MMC Employee Parking Garage - Updated Final Traffic Comments

From: **Tom Errico** <thomas.errico@tylin.com>
Date: Wed, Sep 5, 2018 at 6:55 PM
Subject: RE: MMC Employee Parking Garage - Updated Final Traffic Comments
To: Helen Donaldson <hcd@portlandmaine.gov>

Hi Nell – I have conducted comprehensive review of current application materials and offer the following updated final traffic comments as a status update of prior comments.

CONSIGLI

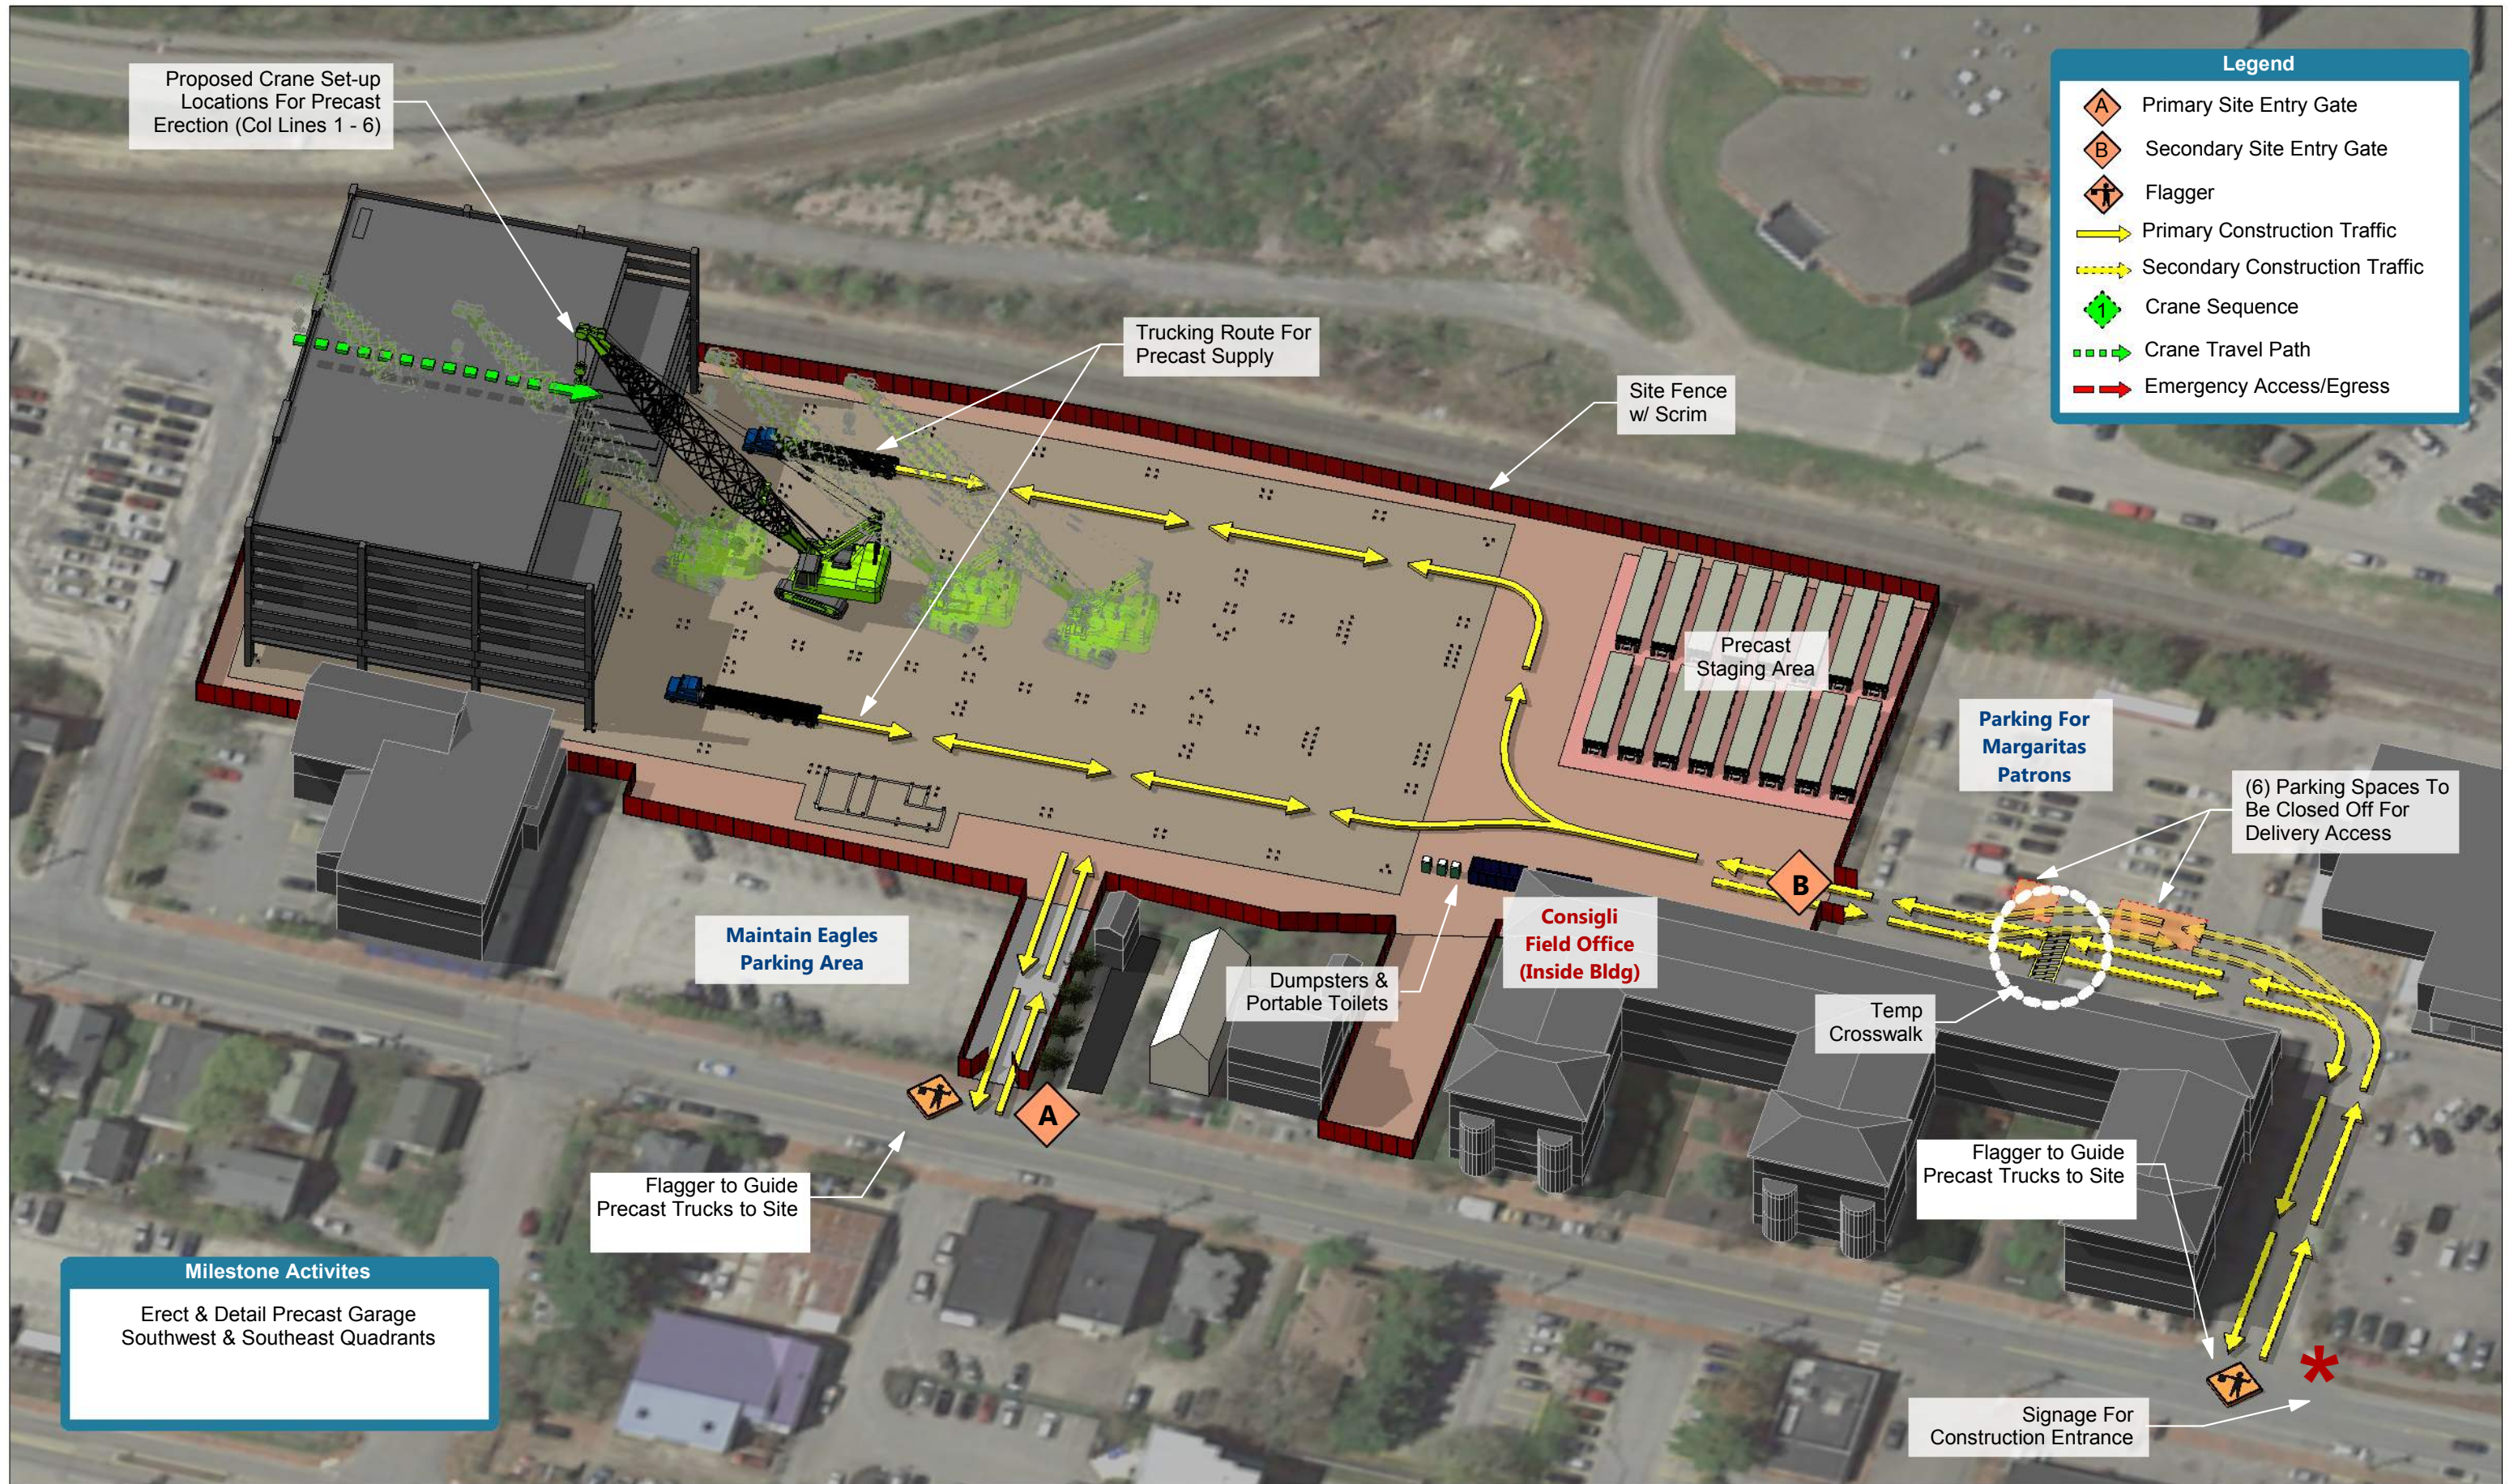
- Construction Management Plan
 - Construction trucks time limits shall be extended to include both MMC and general traffic peak hours.

- All temporary crosswalks shall be ADA compliant.

- Construction plans shall be provided for the roadway/signal work in St. John Street, D Street, and Valley Street.

Updated Status: The plan complies with this request. I have no further comment.

Updated Status: The applicant has acknowledge this requirement and I have no further comment.

Updated Status: A condition of approval shall include development of a Construction Management Plan prior to any City Permit.
